**Response to
Department for Business, Energy and Industrial Strategy
Request for Further Information issued on 31 March 2022
from the Royal Society for the Protection of Birds
and Suffolk Wildlife Trust**

**Application by NNB Generation Company (SZC) Limited for an Order
Granting Development Consent for
The Sizewell C Project**

**Planning Inspectorate Ref: EN010012
The RSPB PINs Registration Identification Ref: 20026628
Suffolk Wildlife Trust Registration Identification Ref: 20026359**

DRAWING TITLE:
PERMANENT COASTAL DEFENCE FEATURE
TYPICAL SECTIONS (MAIN)

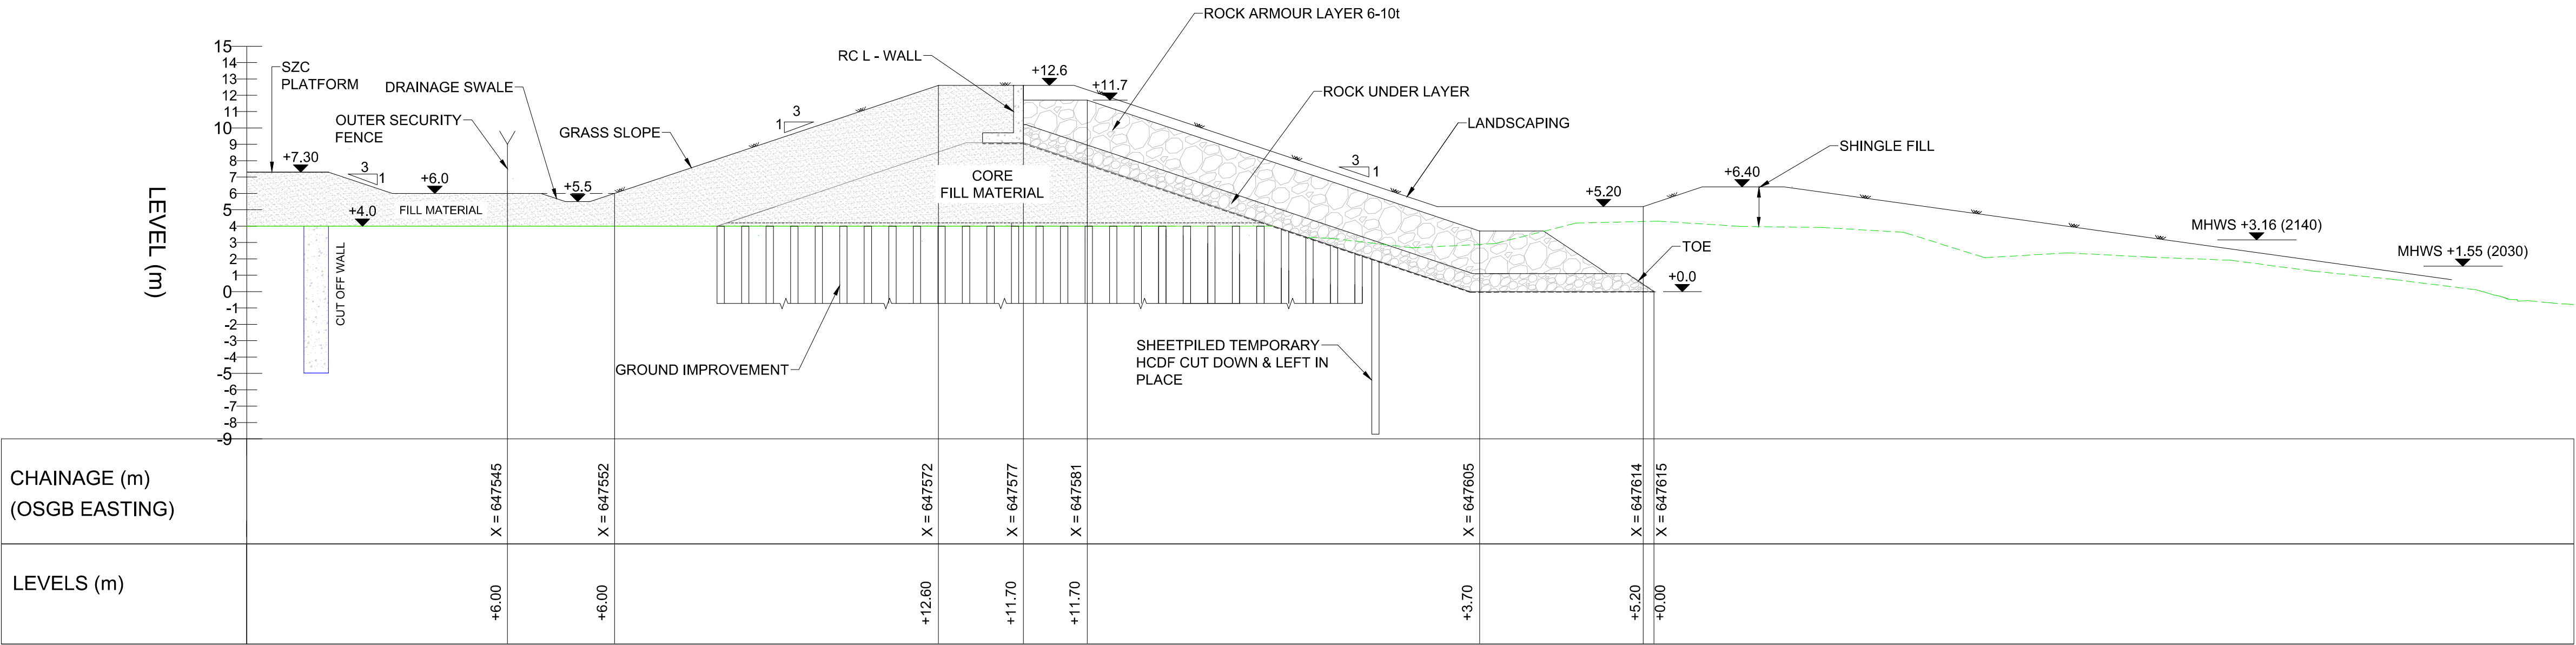
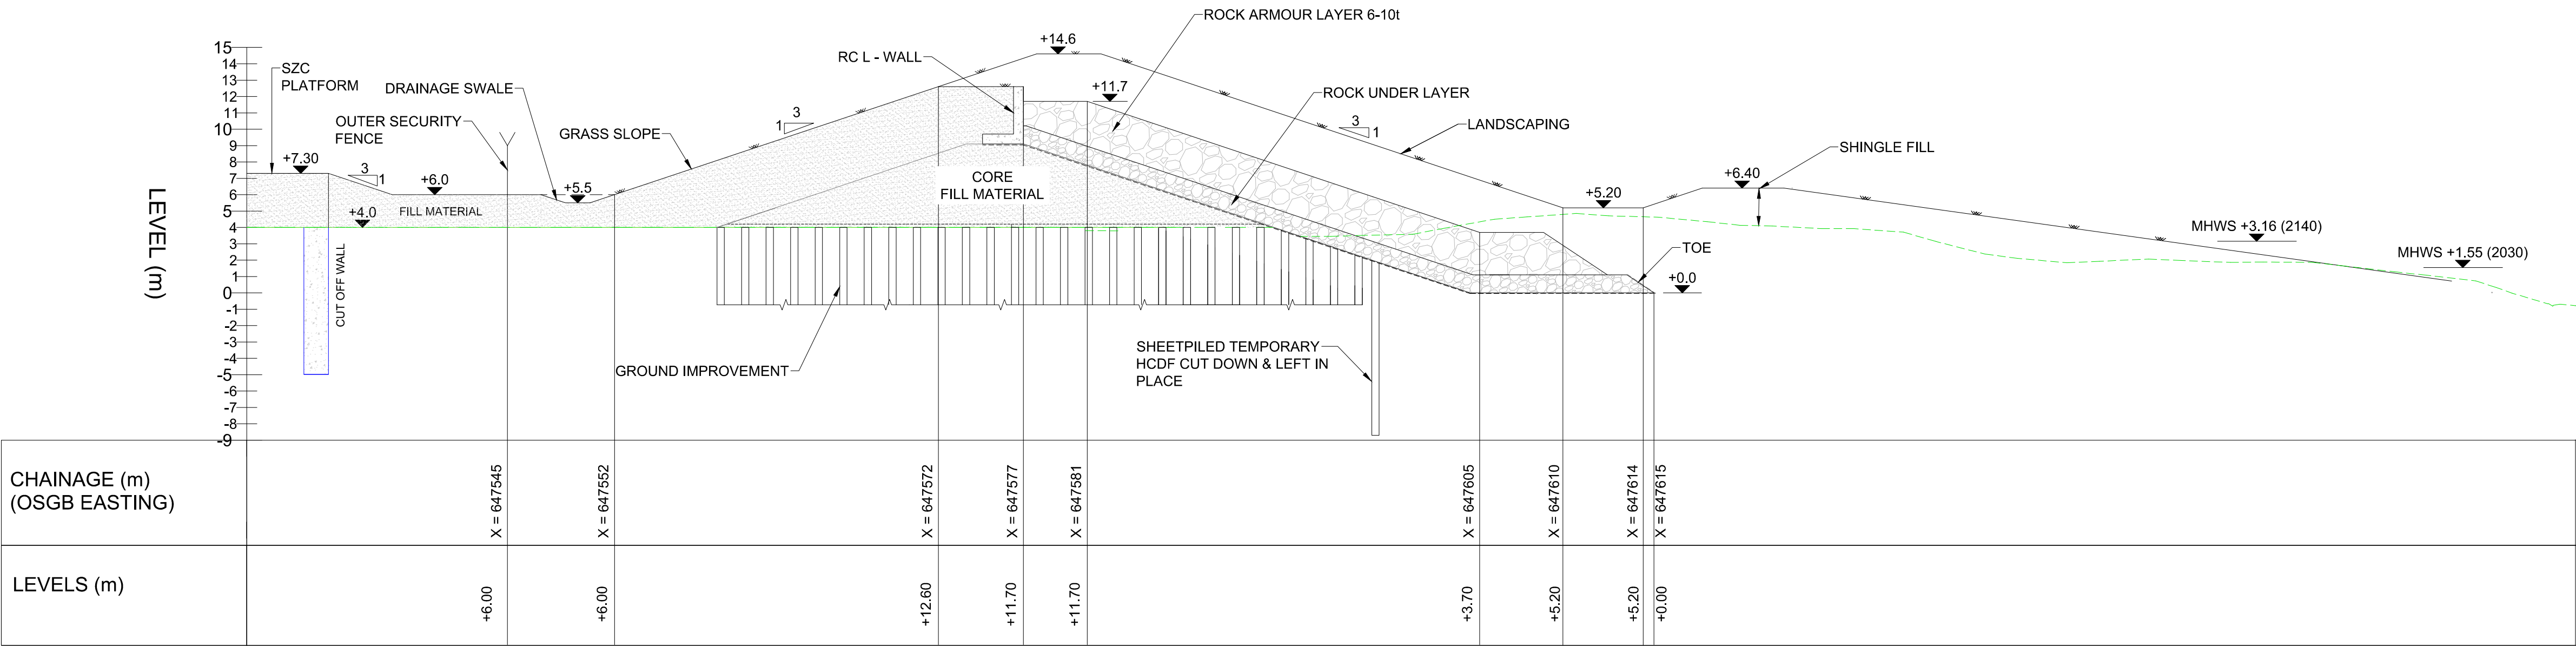
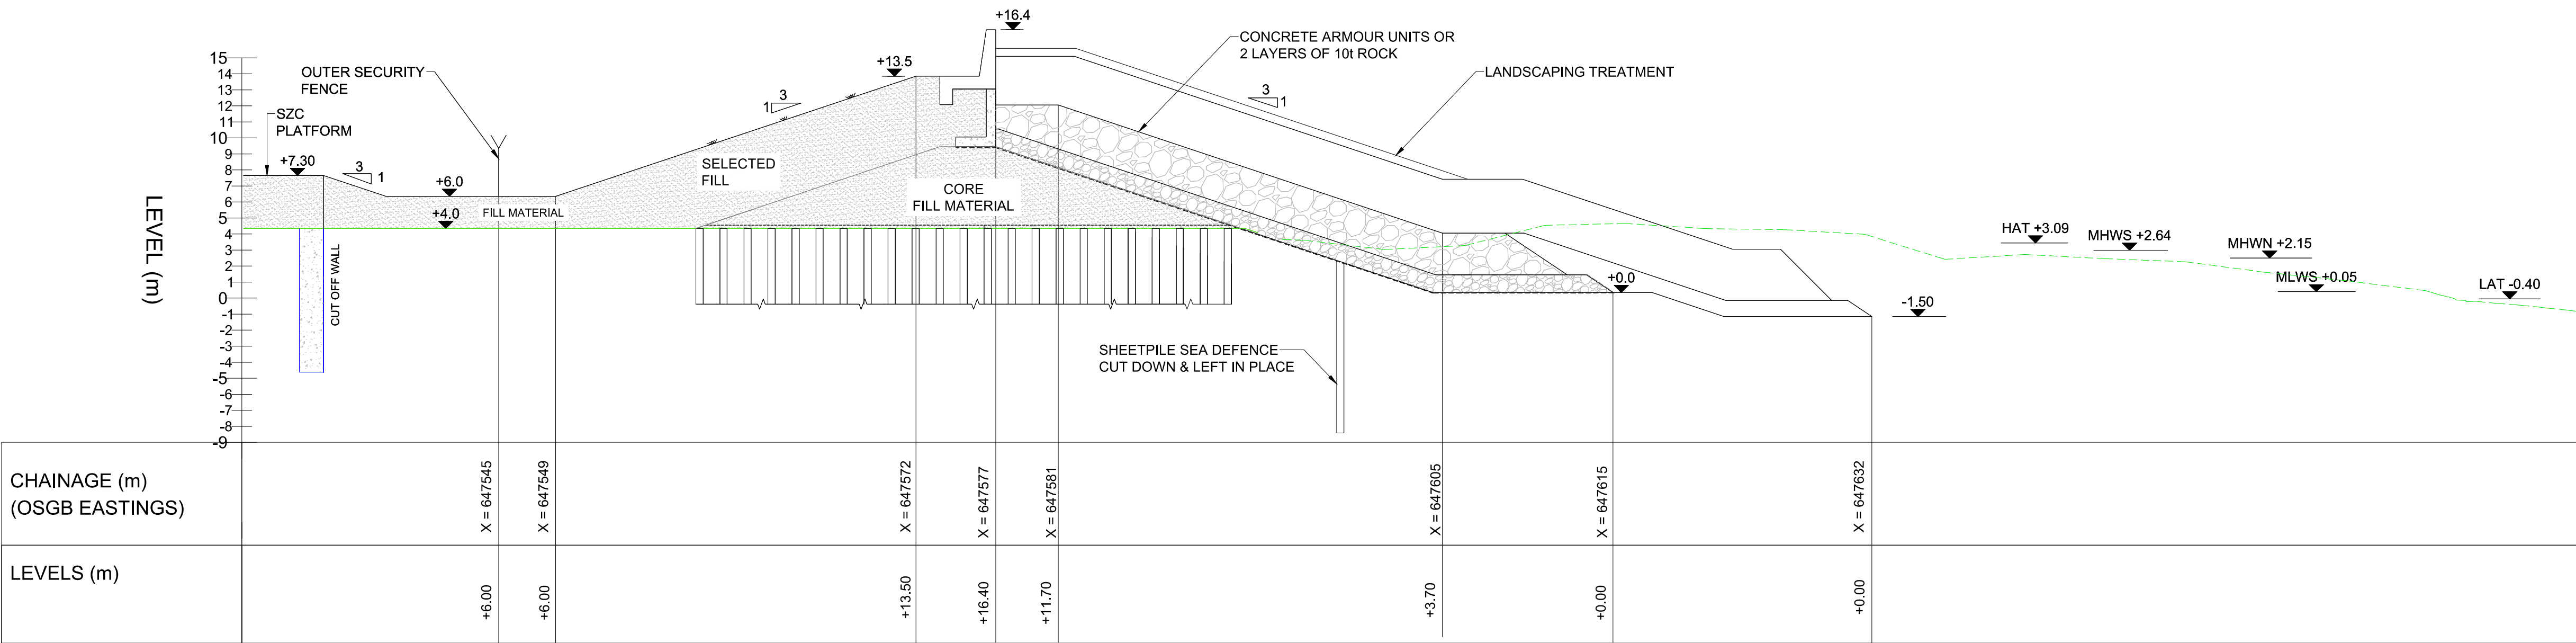
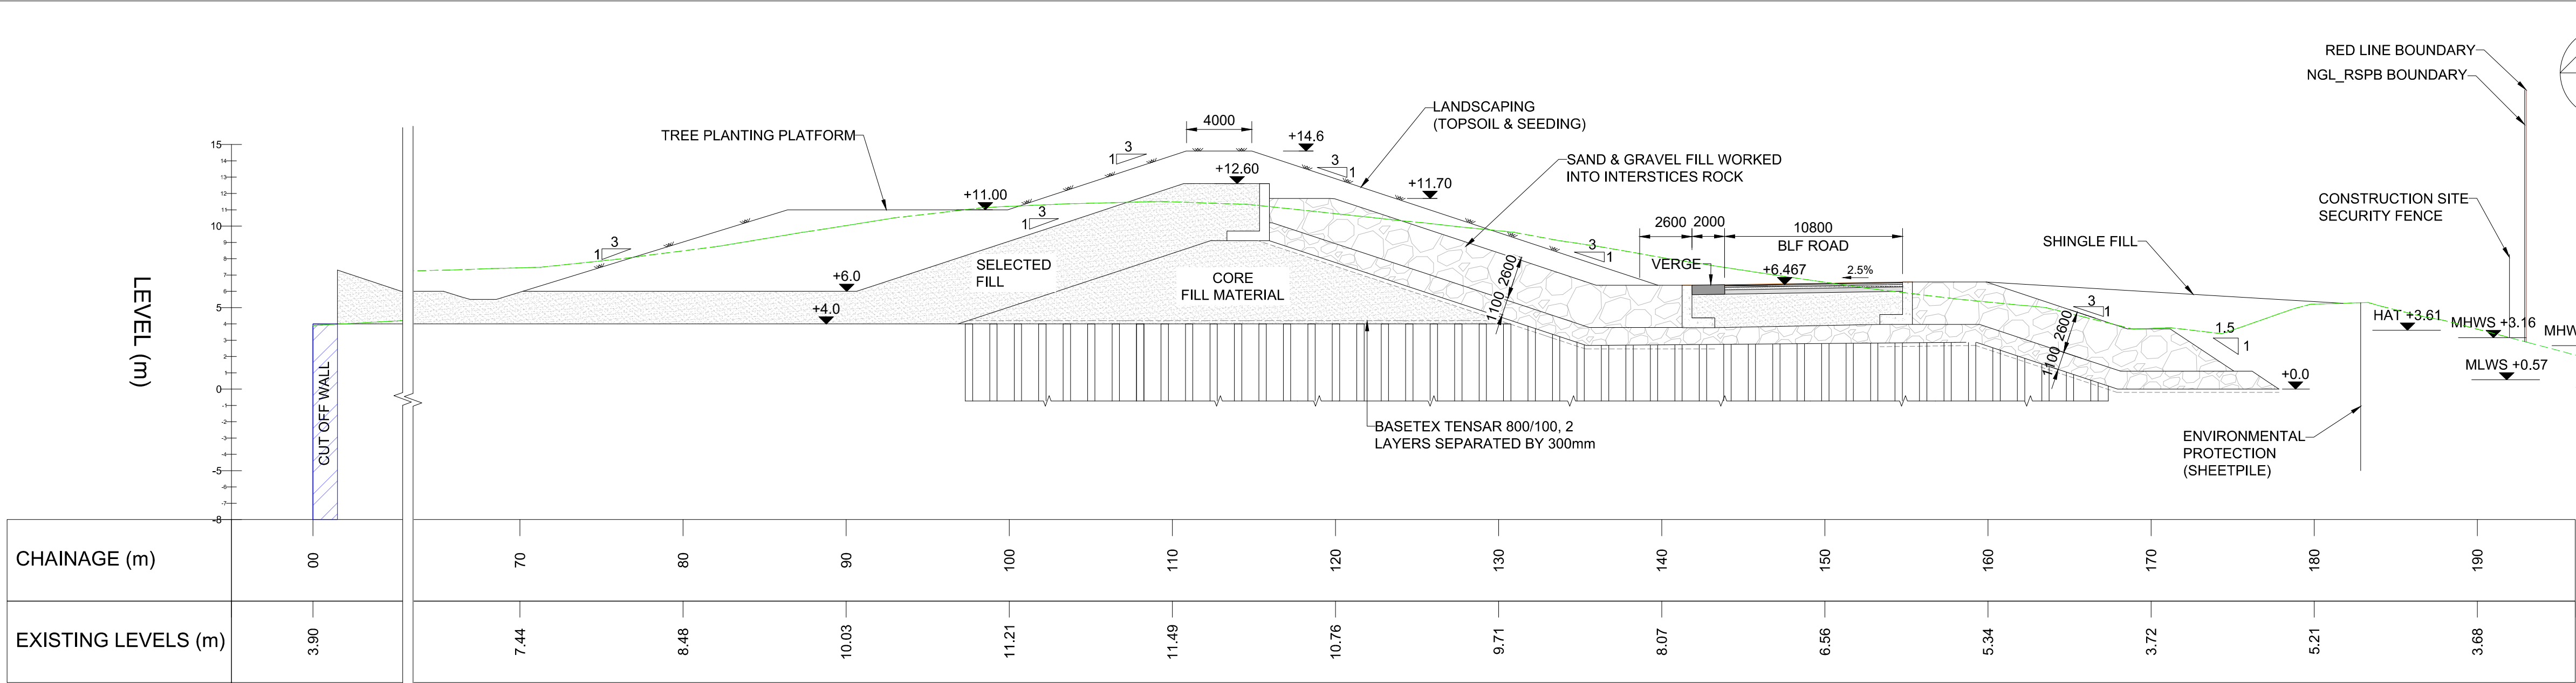
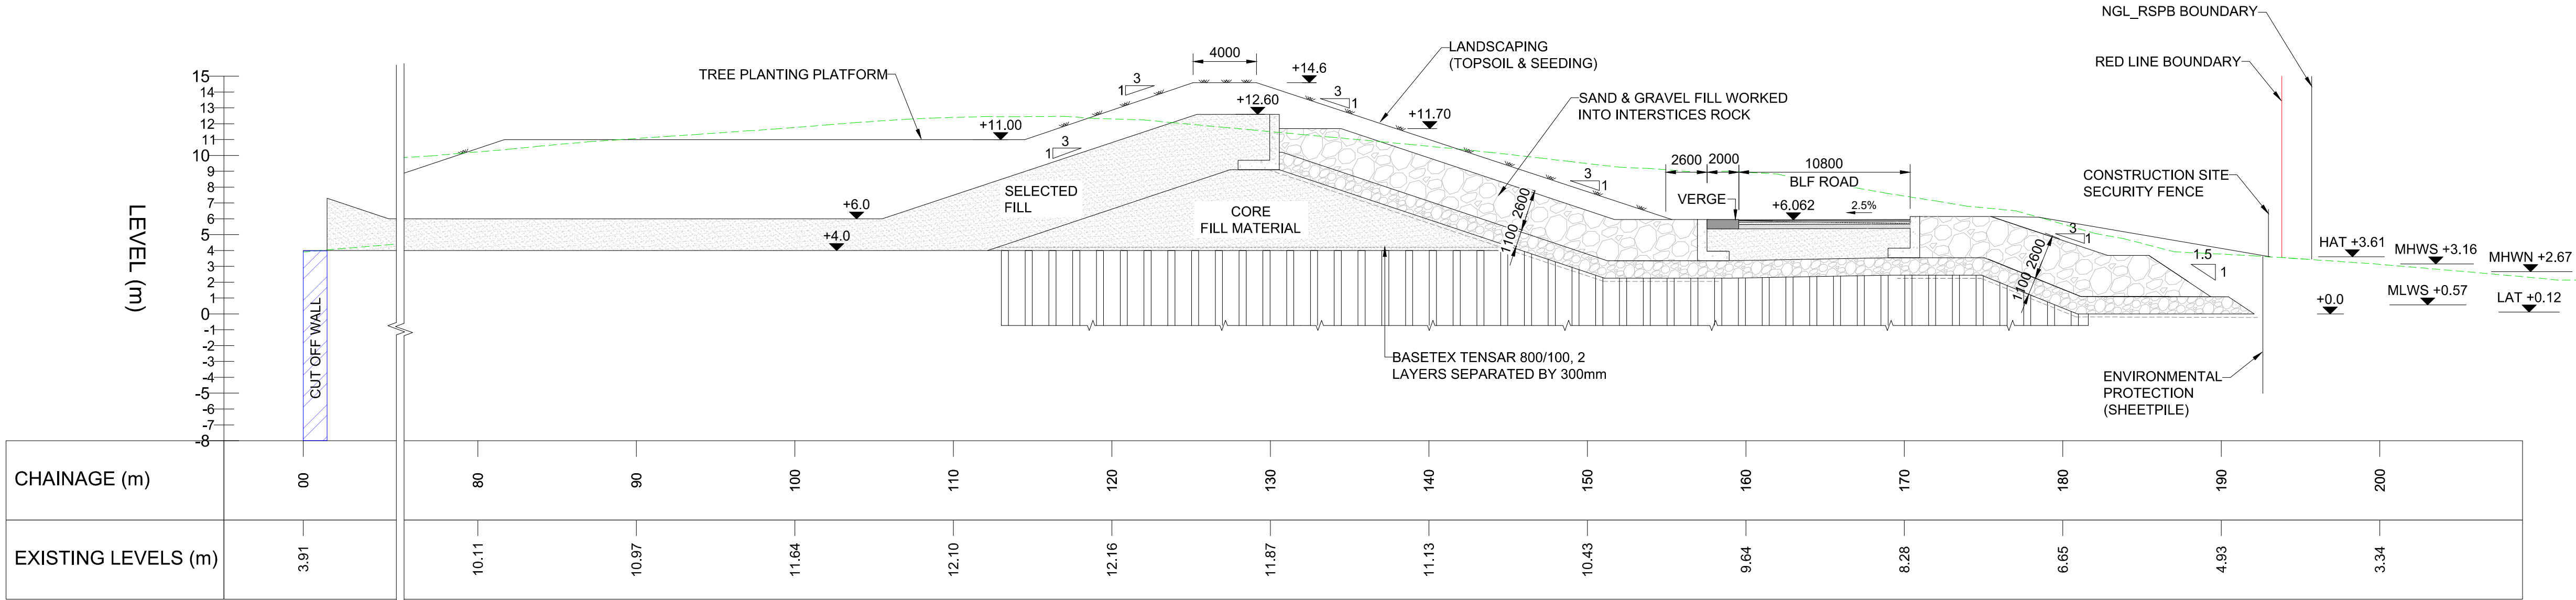
- 1.1.1. the approach to particle size for the Soft Coastal Defence Feature (SCDF) does not appear to be confirmed and there remains a risk that further technical modelling could lead to a decision for coarser material required for engineering function that is not compatible with the ecological function of the neighbouring Minsmere to Walberswick Heaths and Marshes SAC³ (particularly with respect to the annual vegetation of drift lines and the perennial vegetation of stony banks interest features) and Minsmere - Walberswick SPA⁴ (particularly with respect to nesting little tern) and Ramsar site⁵ (particularly with respect to shingle beaches and nesting little tern) (and their underpinning SSSIs)(the protected sites), therefore our concerns about the lasting impacts to those sites remain;

- 1.3. We also welcome that the subsequent paragraph has been amended to reflect the vegetation feature remains *in situ* but we continue to contest the confident assertion that the provision of sediments to the SCDF is likely to provide a benefit to the vegetation communities on the Minsmere frontage (as per section 11.5 of our Examination submission in [REP8-173](#)). This concern also remains due to the approach to particle sizes which retains some uncertainty due to section 2.4 which states that

1.6. This also does not resolve our concerns that the SCDF will not reflect the natural beach particle size required to support the interest features of the protected sites and follows on from our previous concern following Issue Specific Hearing 11 where the Applicant proposed that if material size was fixed it could be problematic to engineering function and it would be better to discharge as a condition in due course (see section 5.14 [REP8-173](#)⁷). We remain concerned that the technical solutions for the SCDF will ultimately be determined by engineering requirements rather than ecological sensitivities. As per our Examination Submissions (see sections 3.108 – 3.122 [REP2-506](#)⁸), the vegetation communities for which the shingle beach is designated and therefore should be protected, require a dynamic environment and are not necessarily supported by ‘increased stability’. In terms of ecological function, the SCDF should retain a sand component that is consistent with the current proportion of sand in the existing beach profiles. The presence of fine particles, including sand, is an important component to enable the shingle beach to support the vegetated conservation interest features of the protected sites. Walmsley and Davy (2001)⁹ reporting on their studies of vegetation establishment at Sizewell following the construction of Sizewell B identified the need for 10 – 20% sand content to enable vegetation to establish.

1.8. The Applicant has failed to present any tangible evidence to support the apparent commitment to retaining the native particle size distribution within and adjacent to the protected sites that we believe is essential to ensuring no adverse effects on integrity to the Minsmere – Walberswick SAC as set out in our previous submissions. We therefore believe this issue has not been satisfactorily resolved and that there is a high level of risk that the technical conclusion in engineering terms will lead to a solution that results in adverse effects on the integrity of the protected sites.

- 1.24. Ultimately, our main concern is the ambiguity over the technical detail with the SCDF and the mechanisms to how this will be resolved. It appears that the most suitable engineering solution could be approved without taking sufficient account of the impacts on the adjacent habitats. We also remain concerned that should damage to the adjacent habitats within protected sites occur, there are no examples of suitable mitigation strategies that could be implemented.
